2019 Financial Assurance Estimate Form
(with pre-plat construction)

PROJECT INFORMATION		
Paintbrush Hills Filing No. 14	1/22/2021	SP206
Project Name	Date	PCD File No.

EXISTING LONDONDERRY DRIVE - NEW STRIPING PLAN
 SCALE 1"=50'

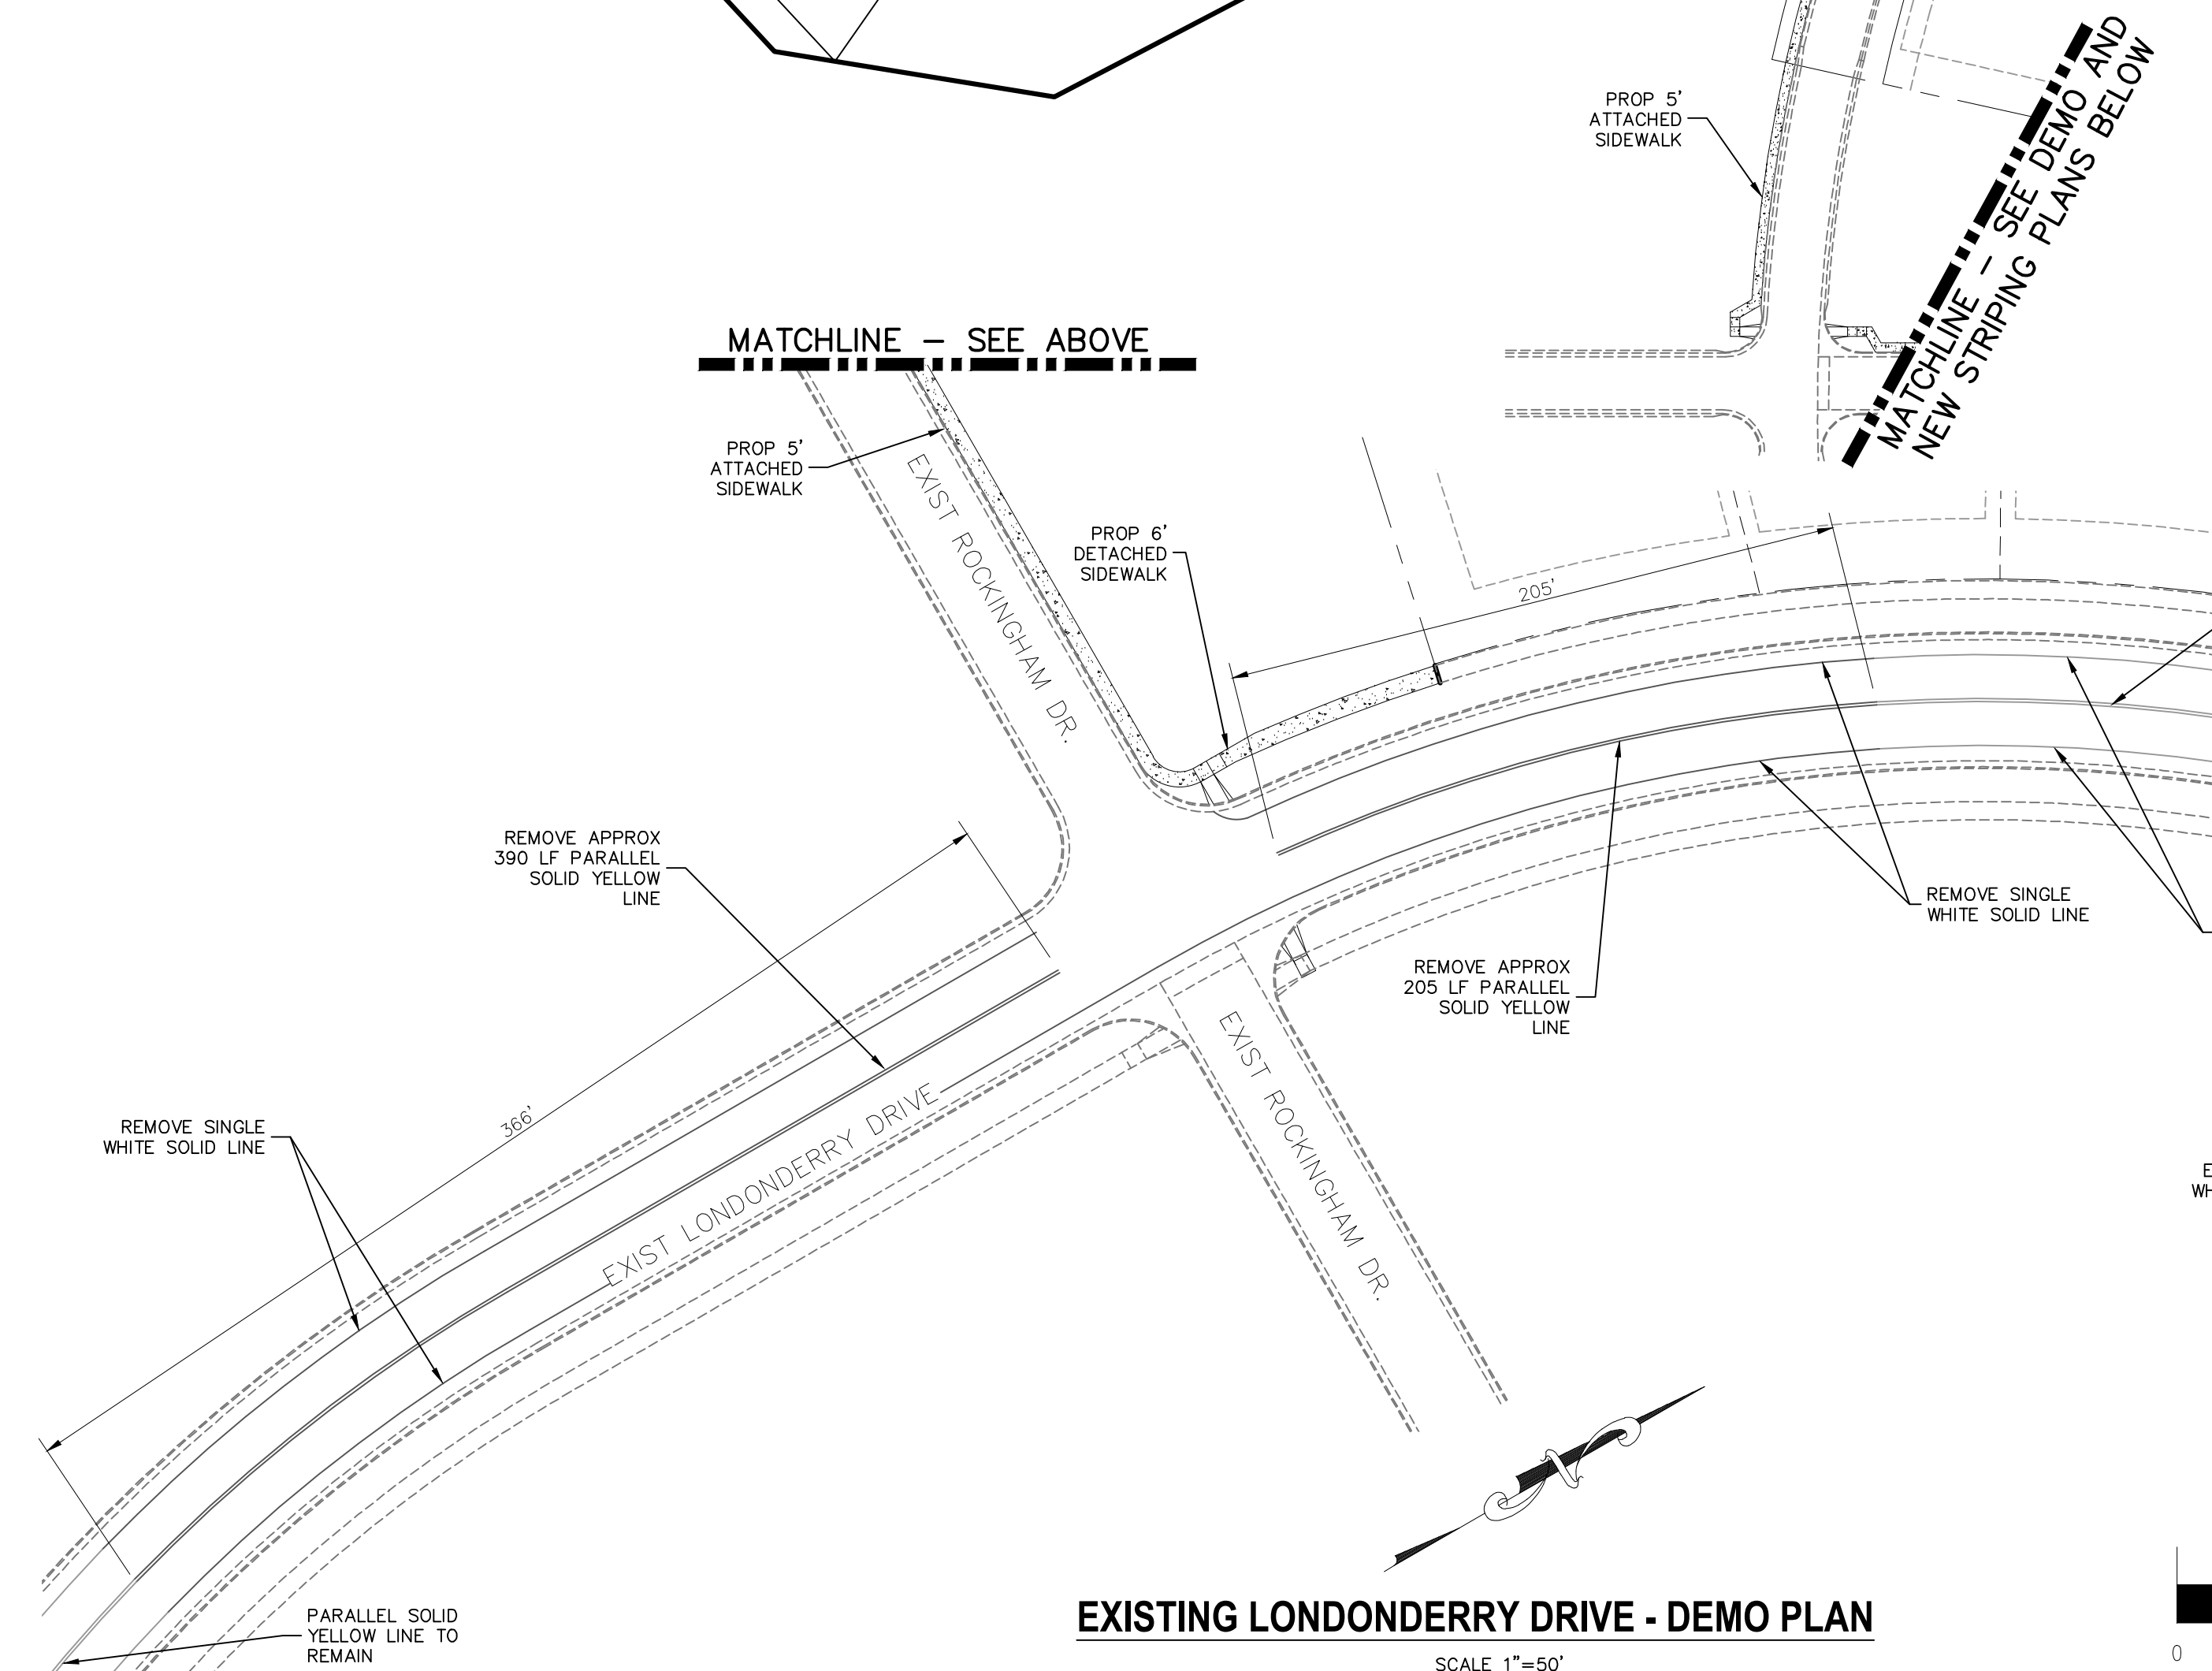
add quantities for restriping on Londonderry per the approved deviation request regarding auxiliary lanes at the Rockingham/Londonderry intersection
